24/02/25

Re. Planning application 2024/93589
26 Hare Park Lane, Hightown, Liversedge WF15 8DQ
Erection of single storey front extension.

Proposed extension

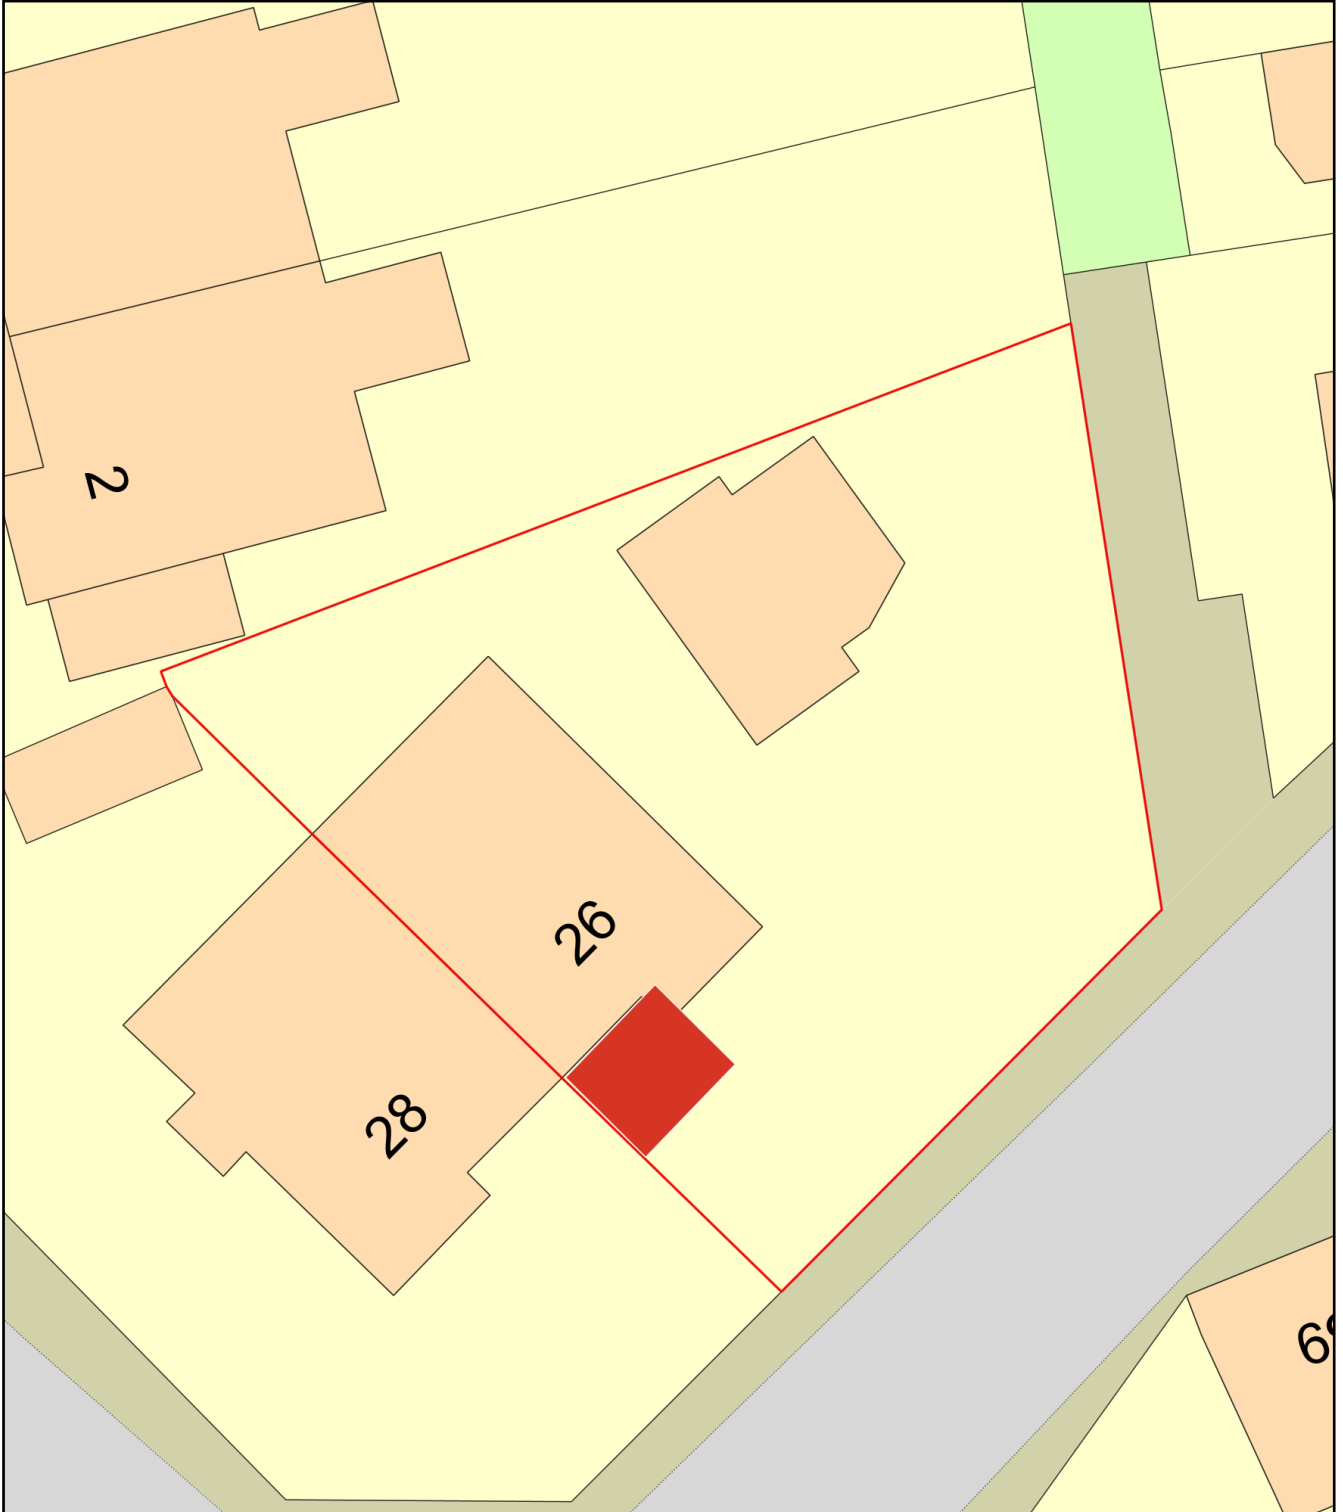
- According to the plans the front aspect of my home will be greatly altered. The French window will be boxed in and a large section of my beech hedge will have been removed and replaced by a 3 metre in length monolith covered in concrete cladding which will dominate my garden. Whereas no. 26 has large gardens to the front, No. 28's garden, because of its border with Hare Park Drive at the side, is fairly small in comparison and is very narrow left of the garden gate. The new extension will overwhelm the garden making it look cramped and dark because of the shade it will create. It may also confuse callers who might think the property is part of no. 26 and will look elsewhere for no. 28.

This extension would be a new addition to the property next door so cannot be termed 'essential repairs' yet the plans appear to me to presuppose access to my garden in order to build it. This would require my permission as the sole owner of 28 Hare Park Lane. I will not be giving my consent to this and, therefore, any encroachment would constitute trespass.

PROPOSED EXTENSION
Plans as proposed

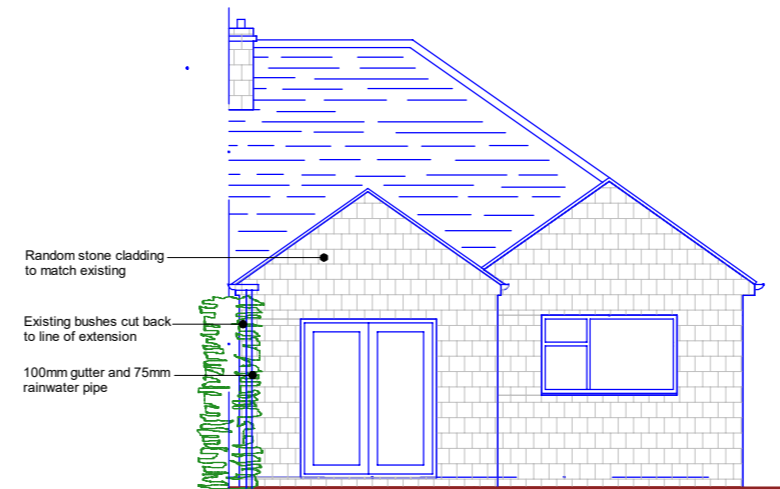
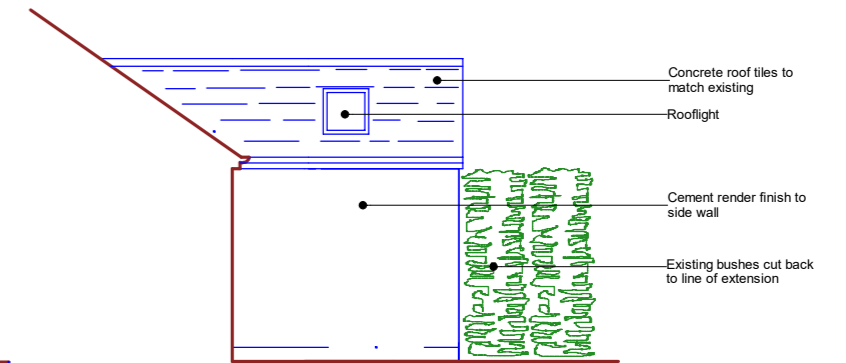
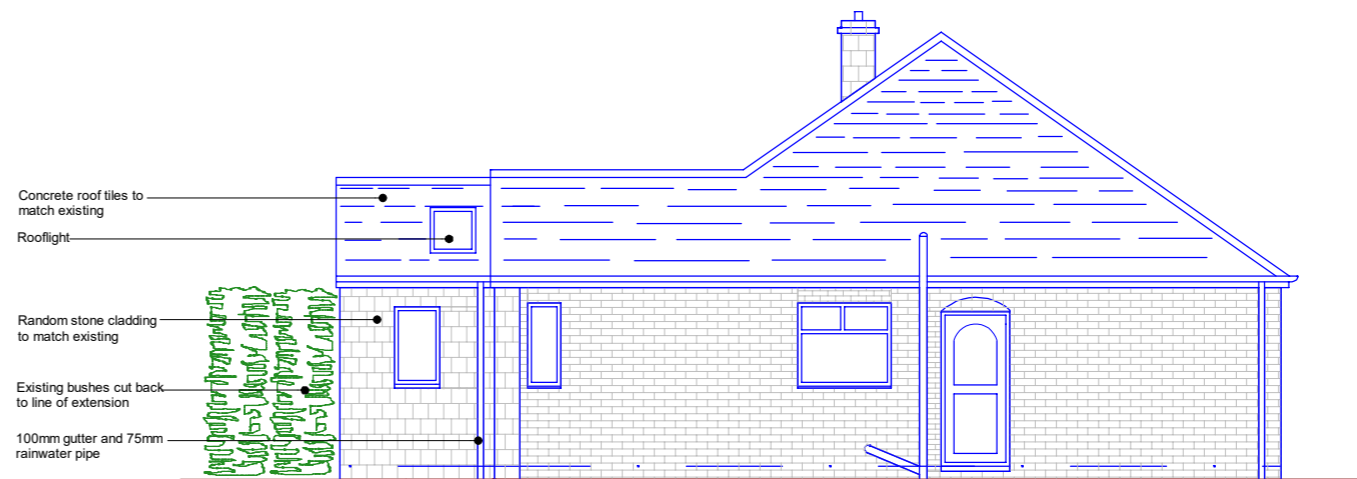
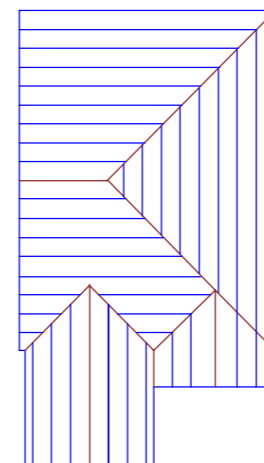
First of all, the proposed extension contravenes the 45 degree Government ruling and will deprive my living room of natural light necessitating prolonged use of artificial lighting. I am with and I no longer drive.

The French window in my living room will be boxed in by the proposed 3 metre extension to the immediate left and the existing (c. 1 metre) projecting kitchen on the right.

- Re. Section 10 Materials: Walls (of the application form), in the 'proposed' column the only information concerns cladding; there is nothing about the foundational materials. 26 and 28 were built of brick and the original owners added the cladding - to the front elevation at 26 and throughout at 28, I note that no. 26's extension is to have "random stone cladding" to "match its existing front elevation". However, the south-west elevation which will ~~face~~ face my garden, forming part of its boundary, will have a "Cement render finish" even though my bungalow is completely covered in random stone cladding.

- Questions about after care arise: The south-west elevation will face directly into my garden. The occupants of no. 26 will not be able to see it and will not be aware of the need for repair if any deterioration occurs. I will be the person directly affected and will have to suffer inconvenience, worry and intrusion. New guttering would have to be attached to the existing gutters and such connections can make the guttering vulnerable to leakages. If any part becomes defective or blocked then the gutters will overflow and in the event of very heavy storms rain will pour down the sloping roof into my garden causing puddles or actual flooding - all this unseen by the occupants of no. 26.
